**Himley Village, NW Bicester
Response to OCC Report of 8th
November 2016**

Prepared for P3 ECo

November 2016

Response to OCC Report dated 8th November 2016

dep. no. <b>166575/301</b>	rev.
-------------------------------	------

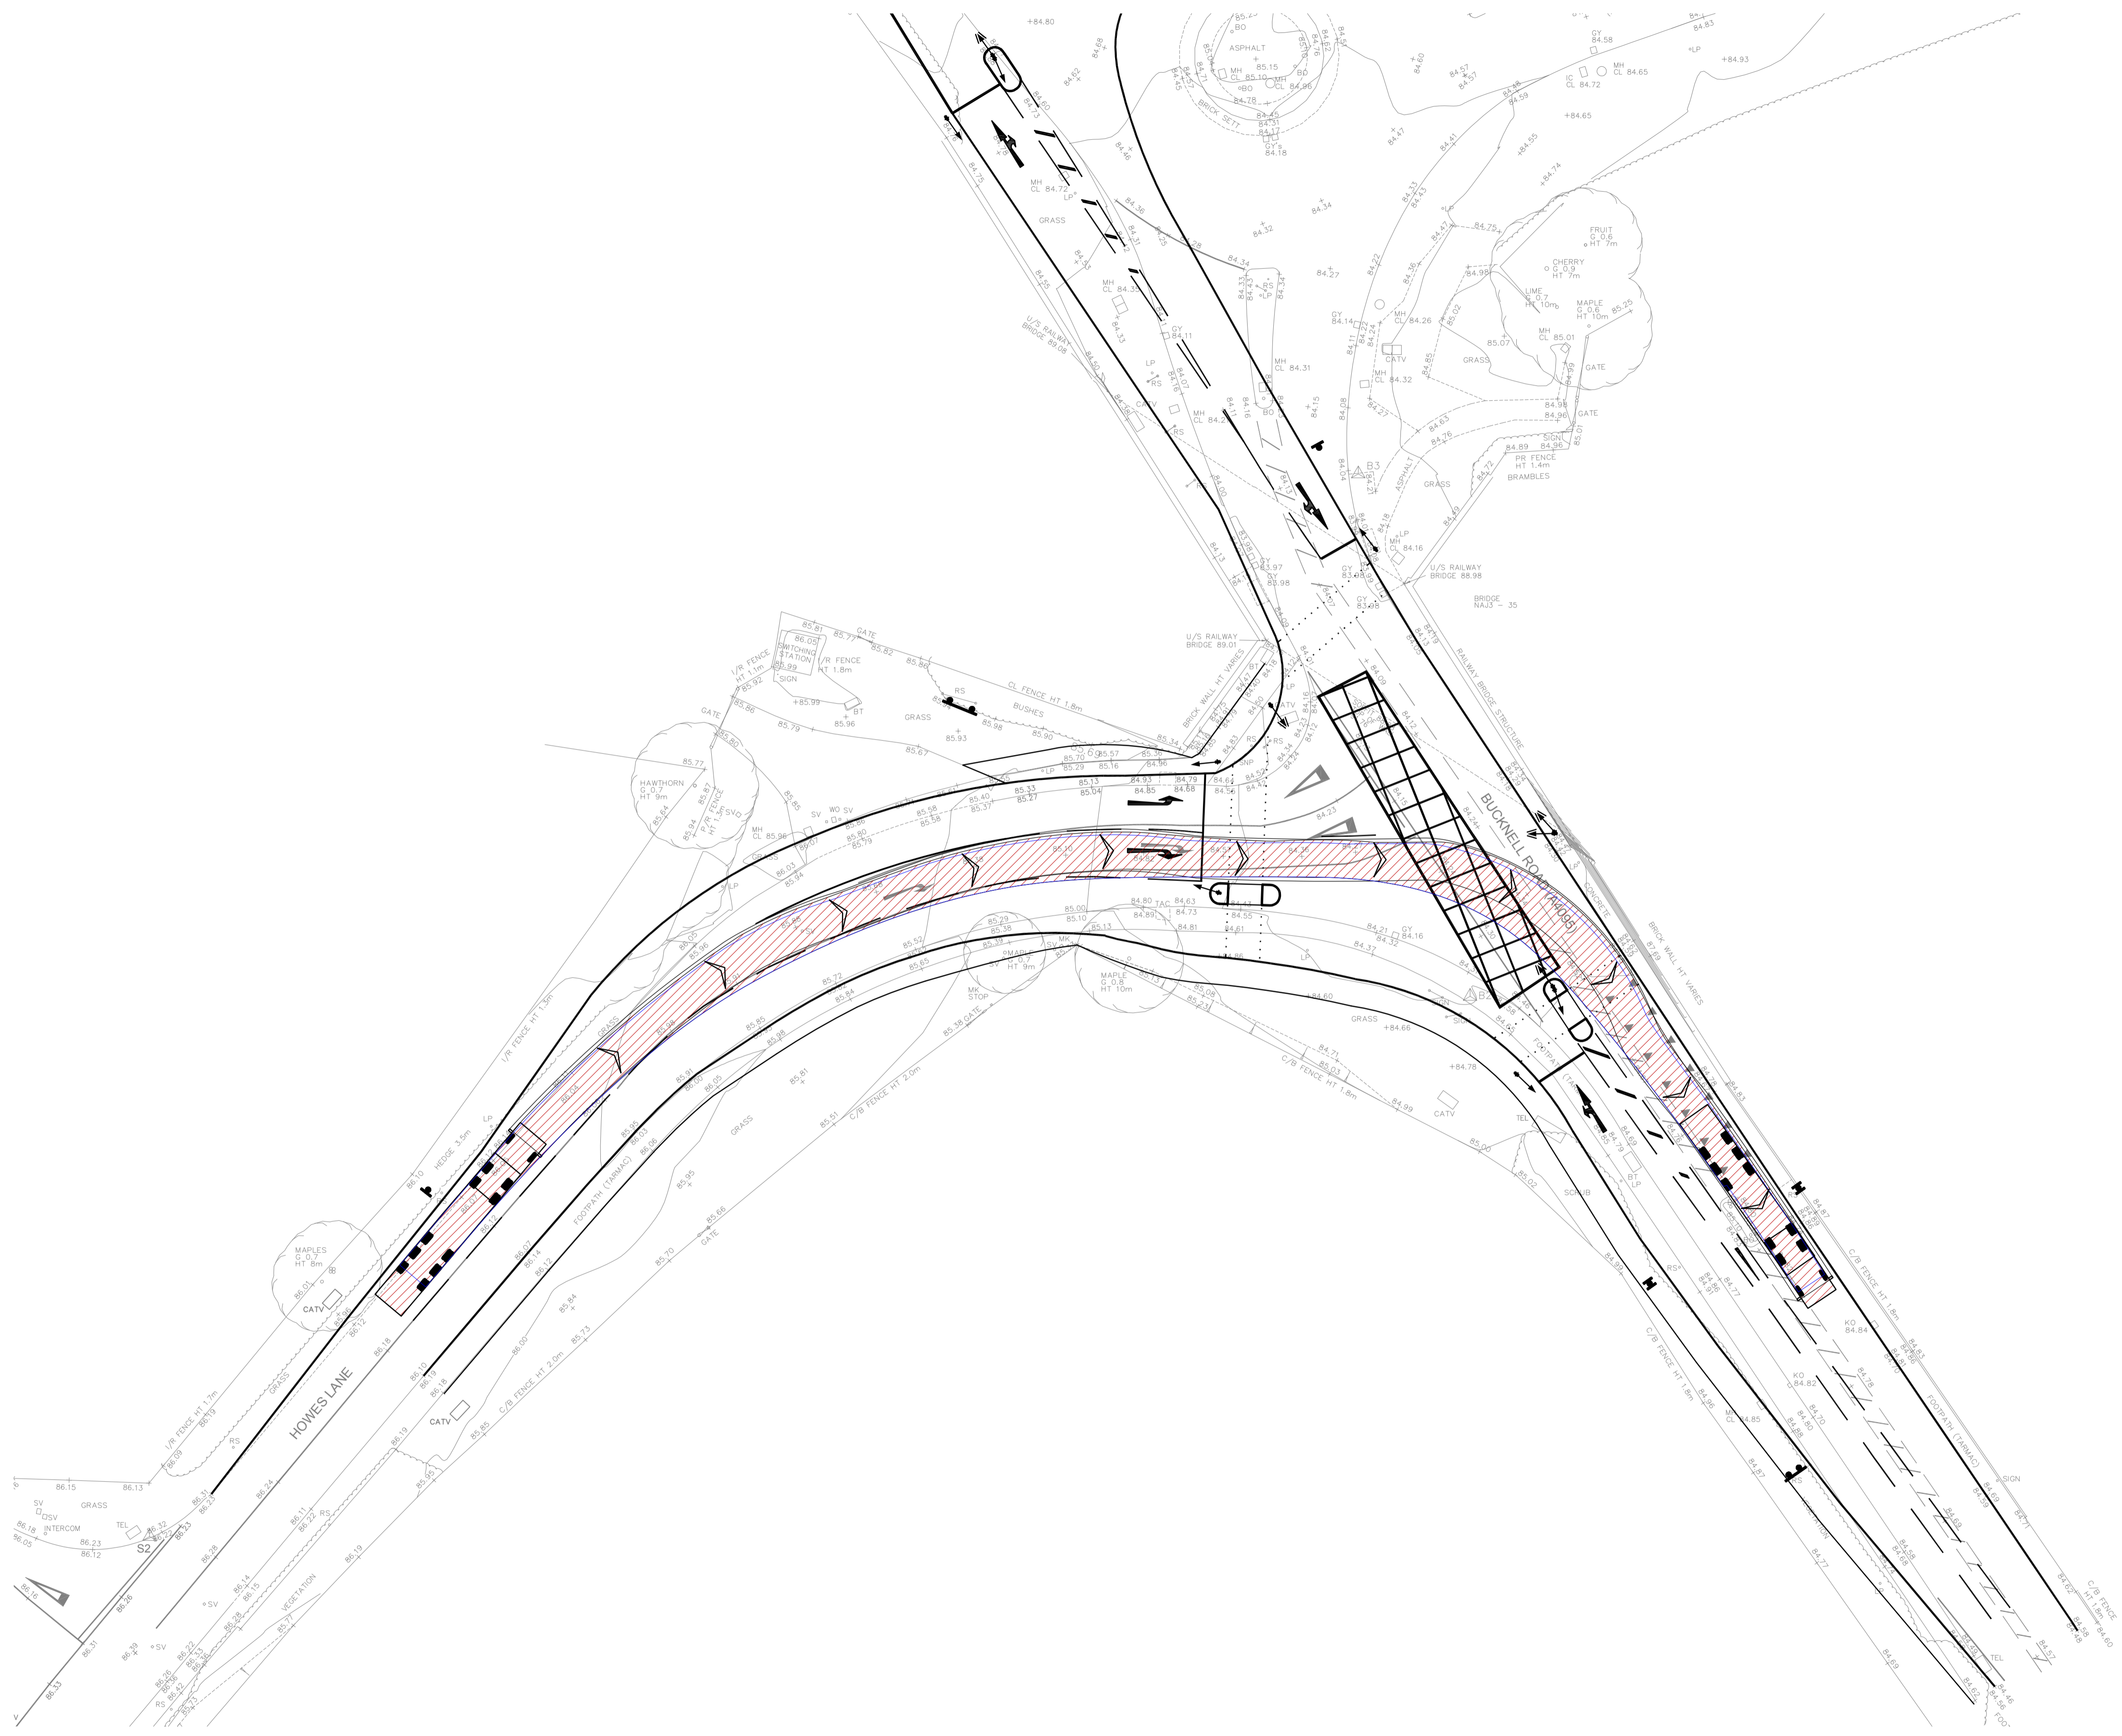
An updated and expanded tracking analysis have been undertaken and this is set out on drawings 1665/75/301 to 330 (Appendix B). The analysis has been undertaken for the following vehicles:

- 16.5m maximum legal articulated HGV
- 15.9m articulated HGV
- 12.0m maximum legal rigid HGV
- 11.0m rigid HGV
- 11.98m bus

The swept paths shown for each vehicle are the body, wing mirrors and wheels combined. The analysis shows that for the range of vehicles selected, all are able to move through the junction while remaining within their designated lane and without conflicting or overhanging kerb lines. This should be contrasted with the existing situation where, as set out above, the Bucknell Road/Howes Lane junction has major issues with the movement of HGVs with implications for both safety and capacity. The interim junction layout fully addresses these issues and is therefore a major improvement on the existing situation.
